From: [Jon Hoekstra](#)
To: [Kelly Bacon \(CD\)](#)
Cc: [Jeremy Johnston](#); [Mark Cook](#); [Josh Fredrickson](#)
Subject: SEPA Comments on DNS regarding SEPA Checklist (SE-22-0002) Cape
Date: Thursday, June 9, 2022 9:32:05 AM
Attachments: [Hoekstra-Steele SEPA Comments-SE-22-00002 9Jun22.pdf](#)

Subject: SEPA Comments on the Determination of Nonsignificance issued by the County regarding SEPA Checklist for Application SE-22-00002 (Cape)

We are writing to provide SEPA comments on the Determination of Nonsignificance (DNS) issued by the County regarding the SEPA Checklist (SE-22-00002 Cape) and associated grading permit application (GP-22-00009).

Soil Map—Kittitas County Area, Washington

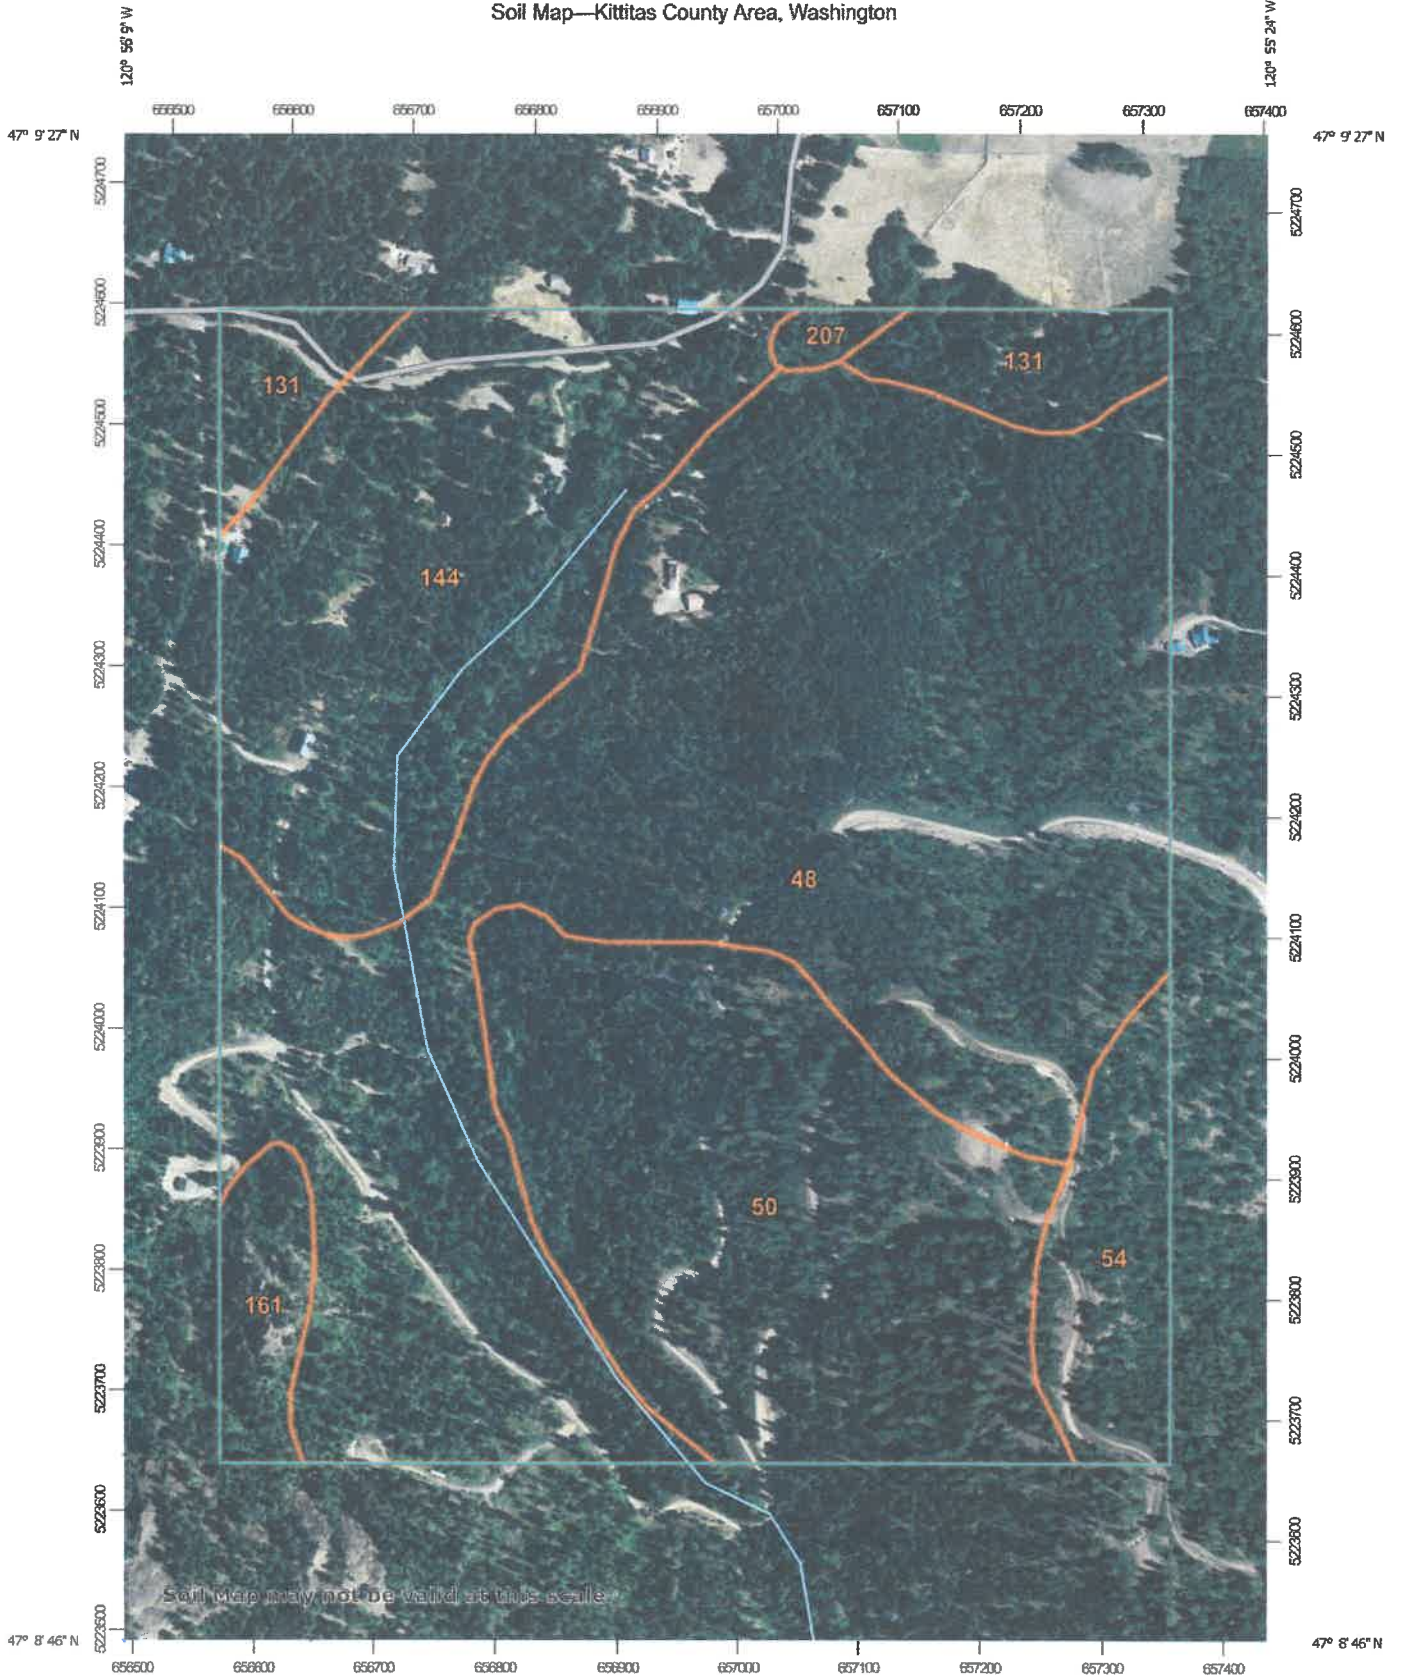
The applicant's response to B.1.b states that the steepest slope on the site is "Approximately 16%." However, the soil map accompanying the SEPA checklist identifies that about 80% of the project area is characterized by soils with 45-65% slopes. The property report for parcel 19162 states that it contains slopes >30%. And in B.8.1.h, the applicant acknowledges that a portion of the road is in a hazardous slope area. Inspection of hazardous slope areas on COMPAS 3.0 indicates that much of the upper portions of the road are in hazardous slope areas.

Parcel #19162 Driveway Improvement Extents

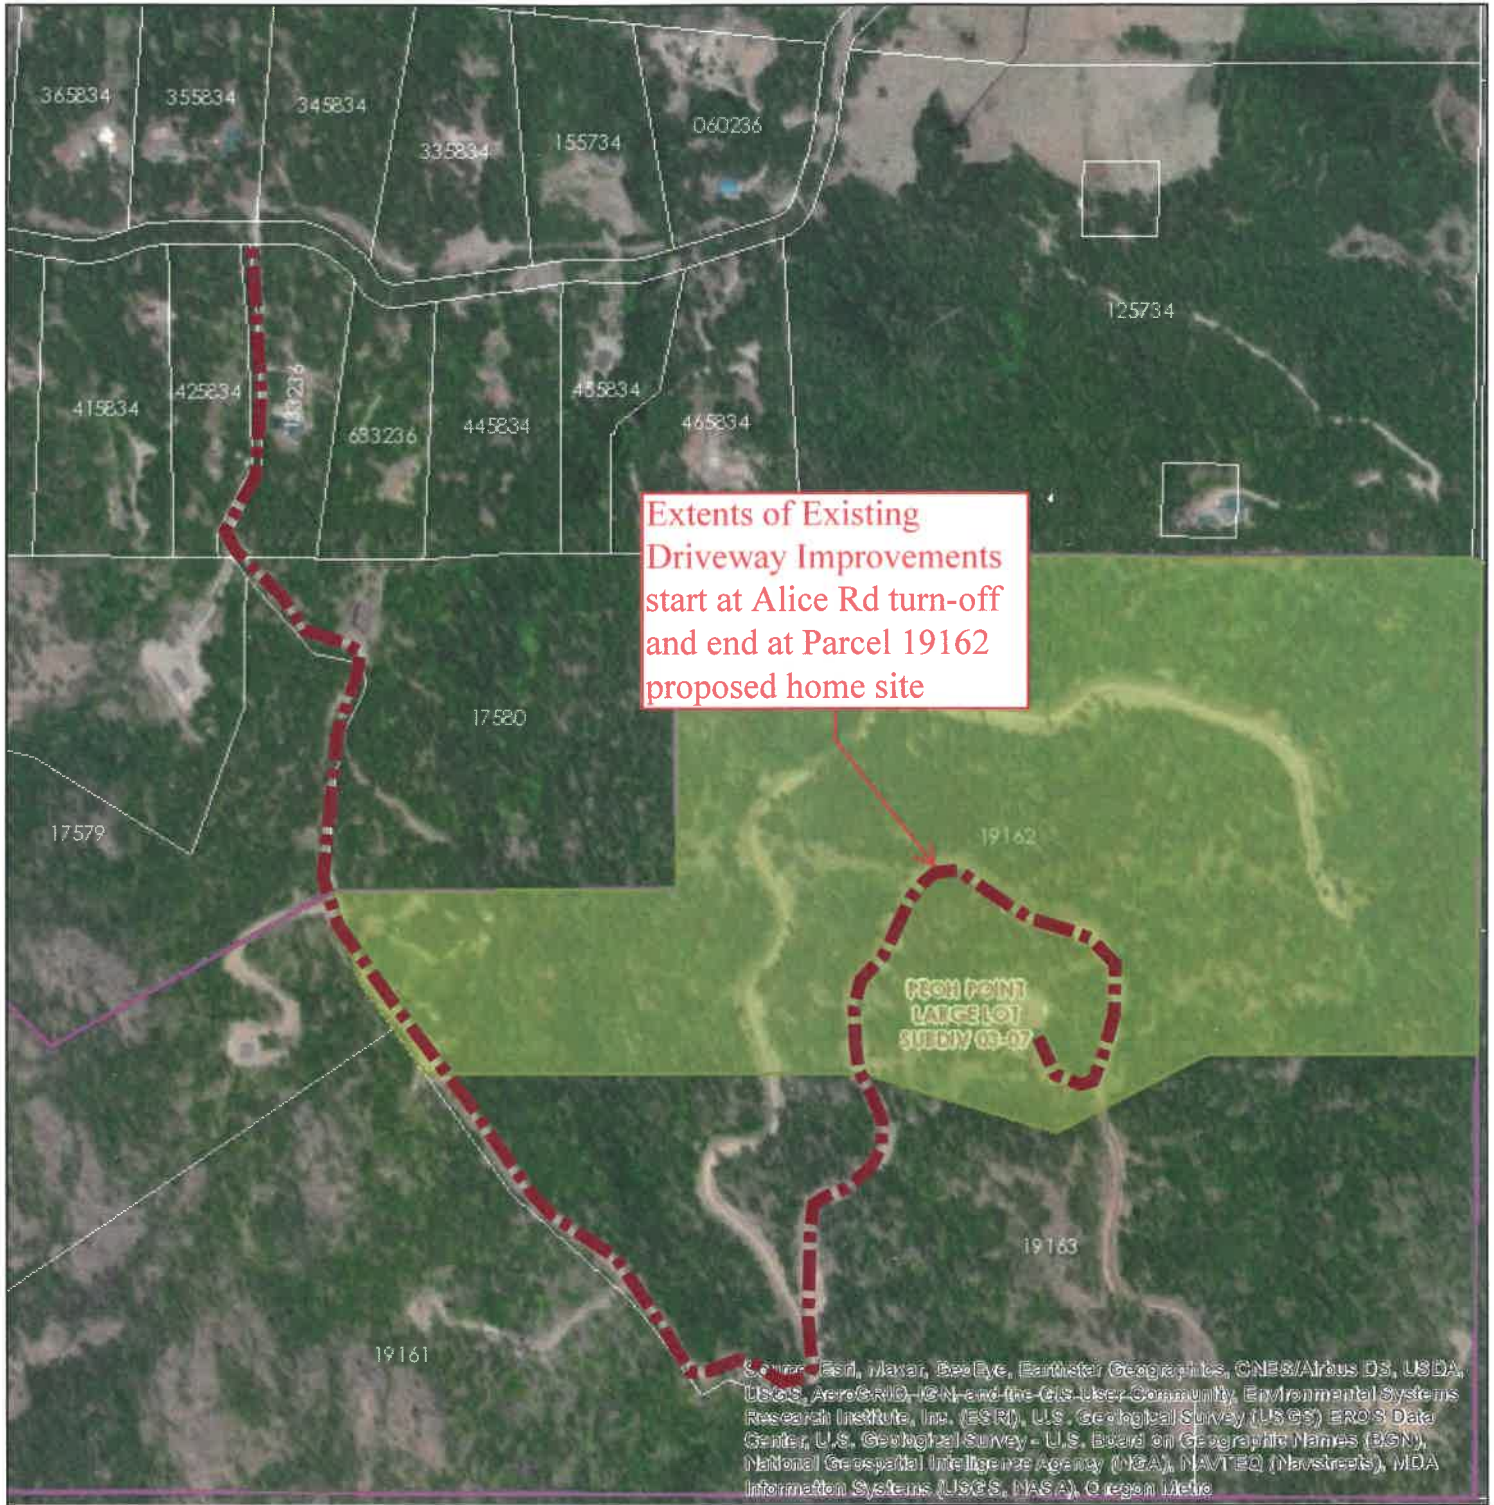
1) The SEPA checklist and project proposal did not properly identify or account for all of the parcels and users that are served by the access road and is thus mischaracterized as a driveway. The access road proposed for grading and improvement is used by the owners of nine separate parcels. At least five of those parcels already have addressed residences, and each residence is accessed from the access road. The proposed residence at 1008 Alice Road (Parcel 19162), which is the subject of the application, would be the sixth improved residence relying on the access road. The remaining parcels also rely on the access road to access their properties for recreational and other uses. For reference, a list of these parcels and respective owners is provided on Attachment A along with maps showing addressed parcels and their respective access points onto the access road. The applicant's own engineering drawings note eight places along the access road where access to adjacent properties needs to be maintained. The number of parcels and users served by the access road exceeds the County's minimum design standards for a "joint use driveway" which is to serve no more than four "parcels and/or units" (see Kittitas County Code 12.04.080, Table 4-4A). Accordingly, under the County Code, the County should require that the proposed project properly adhere to the design standards for a private road serving 3-14 parcels and/or users.

2) The SEPA checklist and determination did not adequately address or evaluate the presence of steep grades along the access road. While the checklist identified that portions of the existing access road "is in a hazardous slope area" and noted that the "steepest slope on the site" is "[a]pproximately 16%", no further evaluation of such critical area or steep slope concerns was addressed. In fact, as the application materials detail, adjacent slopes at the larger site are in places "over 25%," and reiterate that grades along the proposed improved access road are up to 16%.

These slopes exceed the maximum slopes allowed under the minimum design requirements for private roads. See KCC 12.04.080, Table 4-4A; see also KCC 12.04.080 Table 4-4B. Notably, the access road exceeds the 15% grade as it approaches Alice Road. As residents living immediately downhill of that intersection, we are concerned that vehicles traveling downhill, especially during winter or inclement weather, could lose control and fail to stop at the intersection and crash into cross traffic or our property. We are also concerned that a paved surface will accelerate runoff and funnel stormwater flows to the bottom of the hill where they could washout Alice Road or flood our property if drainage controls are inadequately engineered or inappropriately constructed. These concerns were not sufficiently disclosed or evaluated in the SEPA determination.

3) The SEPA checklist and determination did not adequately address the right of way for the proposed widening and paving project where it passes through the easement from Alice Road through the Little Peoh Point Tracts. The easement for the portion of the access road is 30 feet wide at its northern extent as it approaches Alice Road. When properly evaluated as a private road instead of a driveway, under the County Code, there is insufficient right-of-way. As proposed, the project roadway improvements include two 10-foot lanes with 1-foot shoulders and 4-foot drainage ditches on either side for a total width of 30 feet. While this might technically “fit” within the easement, there is no margin for alignment errors that would encroach on adjacent properties, and a narrower roadway would fail to meet minimum design standards.

The extents accompanying the SEPA checklist identify approximately 1.34 miles of "driveway" that is proposed to be paved, of which more than 60% runs through these other owners'

properties, *not* on the applicant's parcel. This raises fundamental questions about whether the applicant has any right to alter and independently pave a road through someone else's private property, and whether the County can permit such action without the affected owners' consent?
